Rezoning Petition Review

Rezoning Petition #: 08-117

Location of Property: Approximately 9.00 acres located on the east side of Toddville Road between Paw Creek Road and Freedom Drive.

**TECHNICAL DATA SHEET**

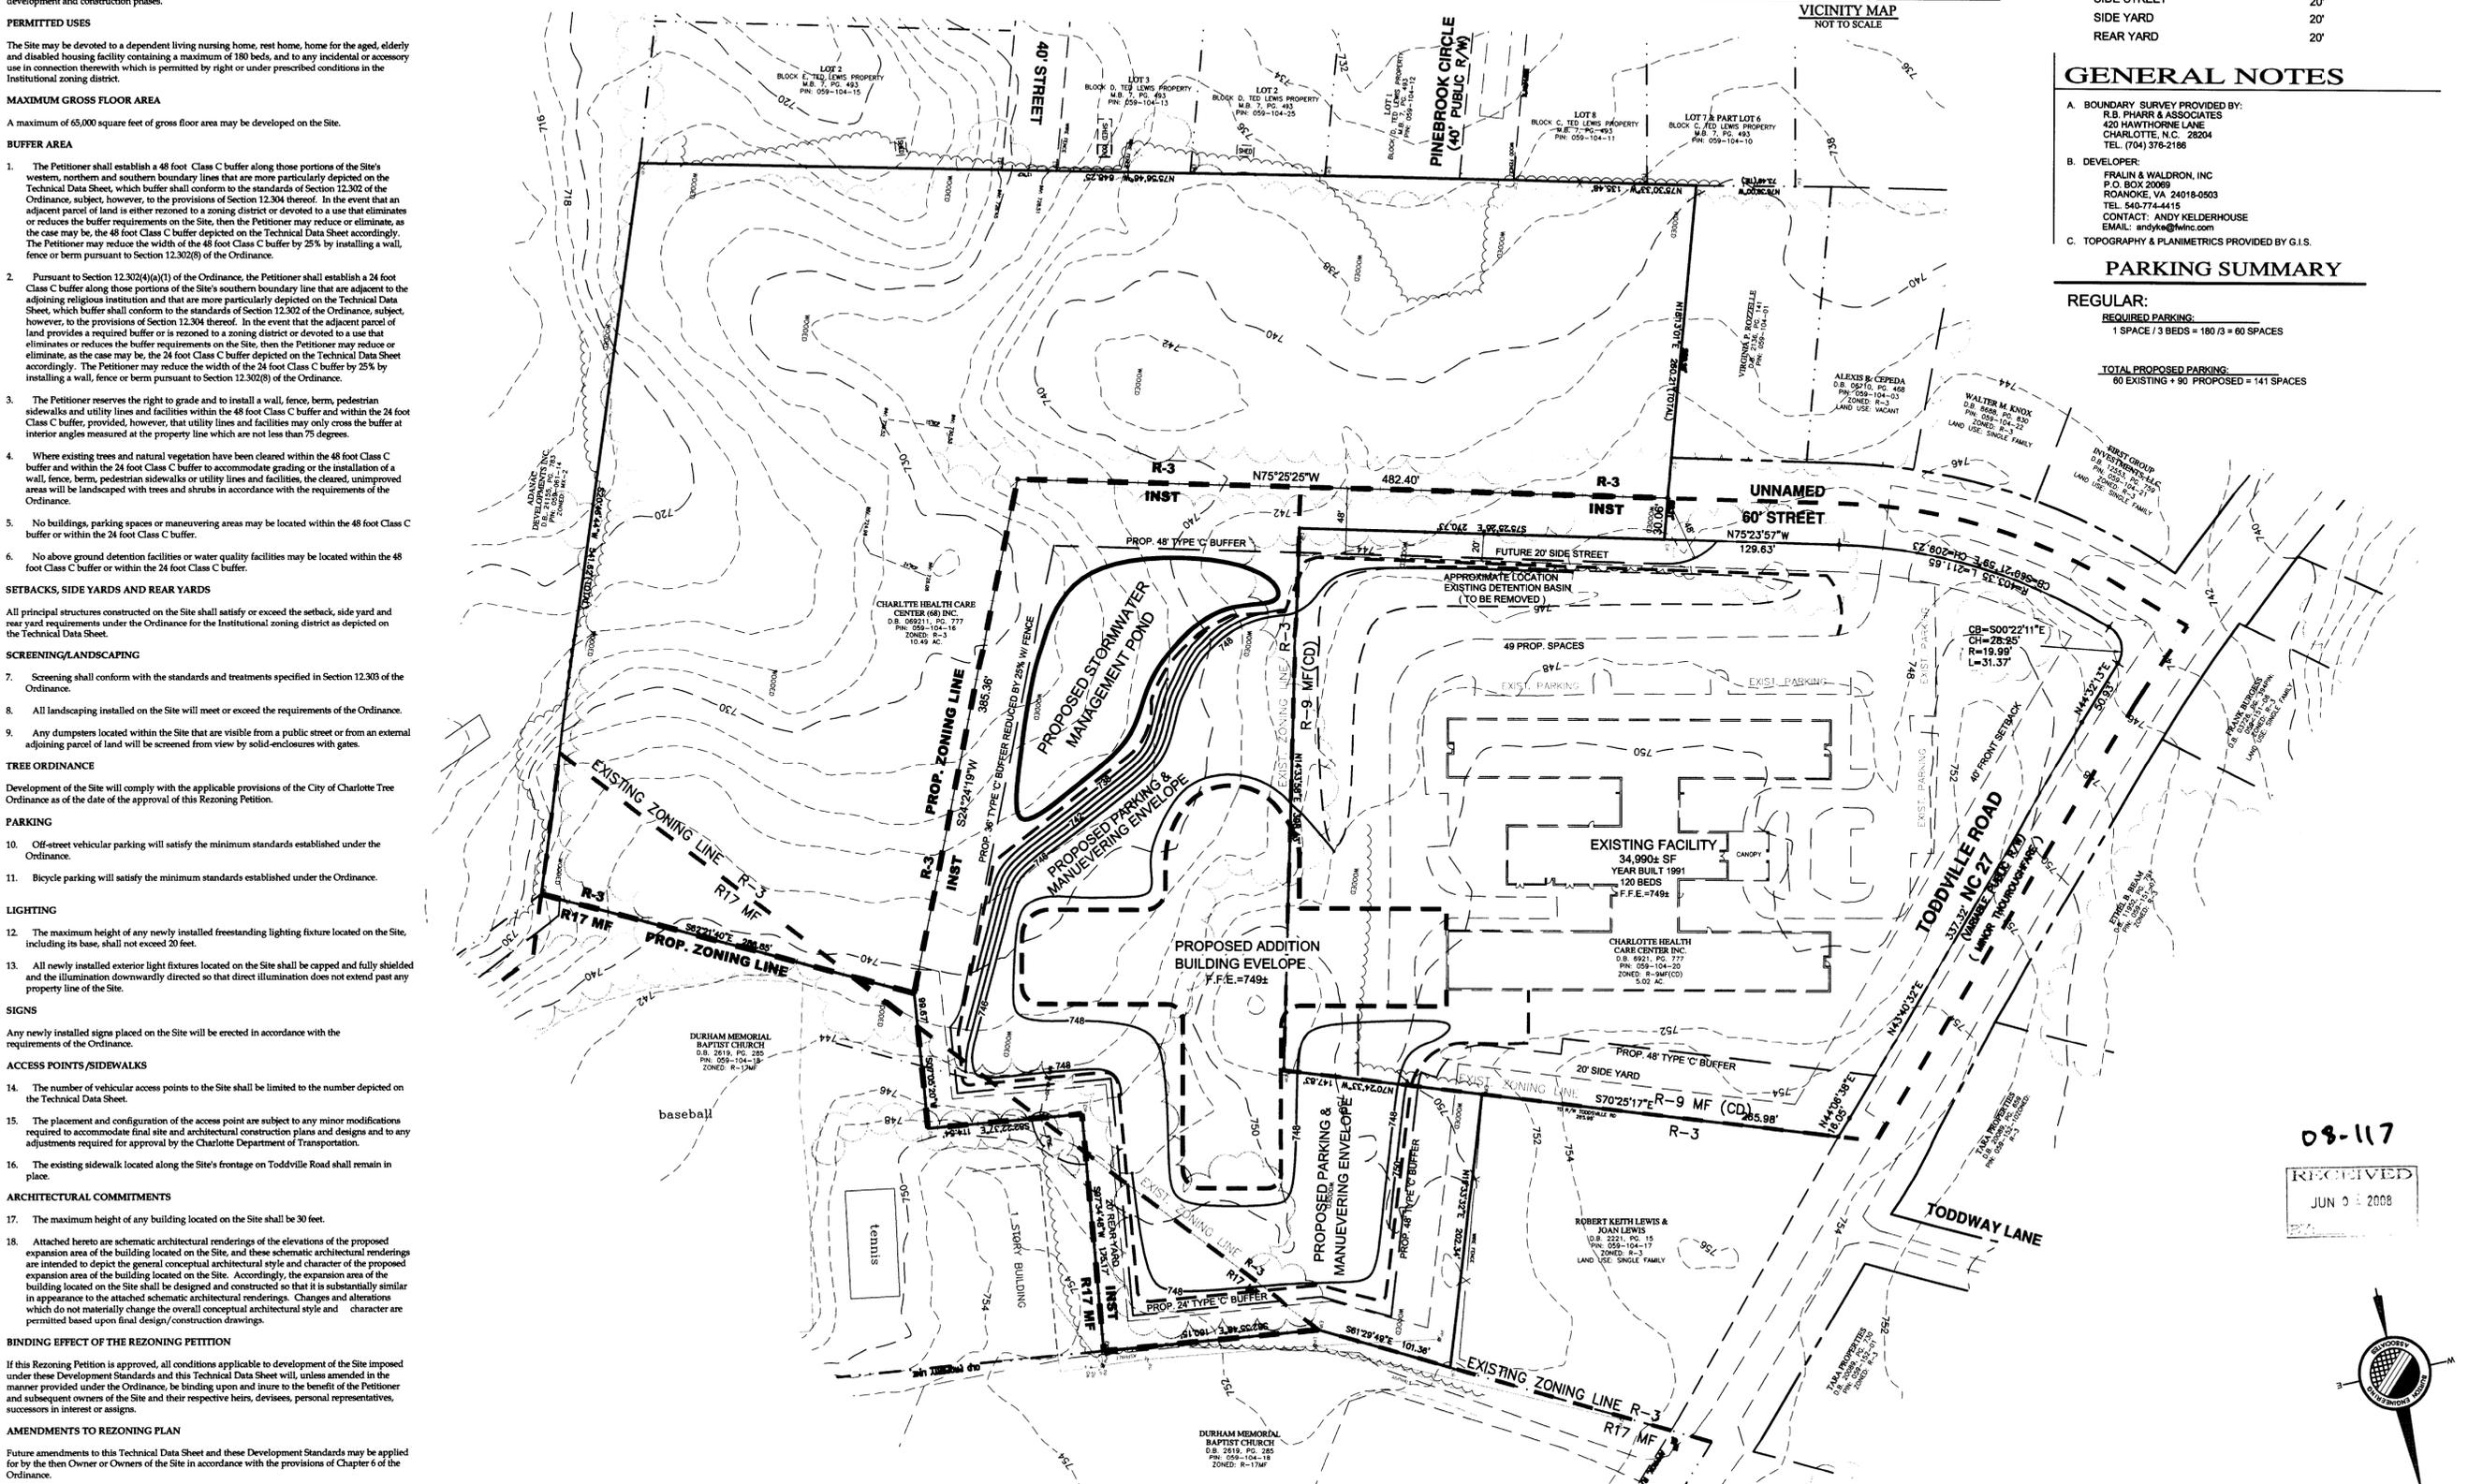
Concerning Storm Water: **Add the following note**

The petitioner shall comply with the Charlotte City Council approved and adopted Post Construction Controls Ordinance.
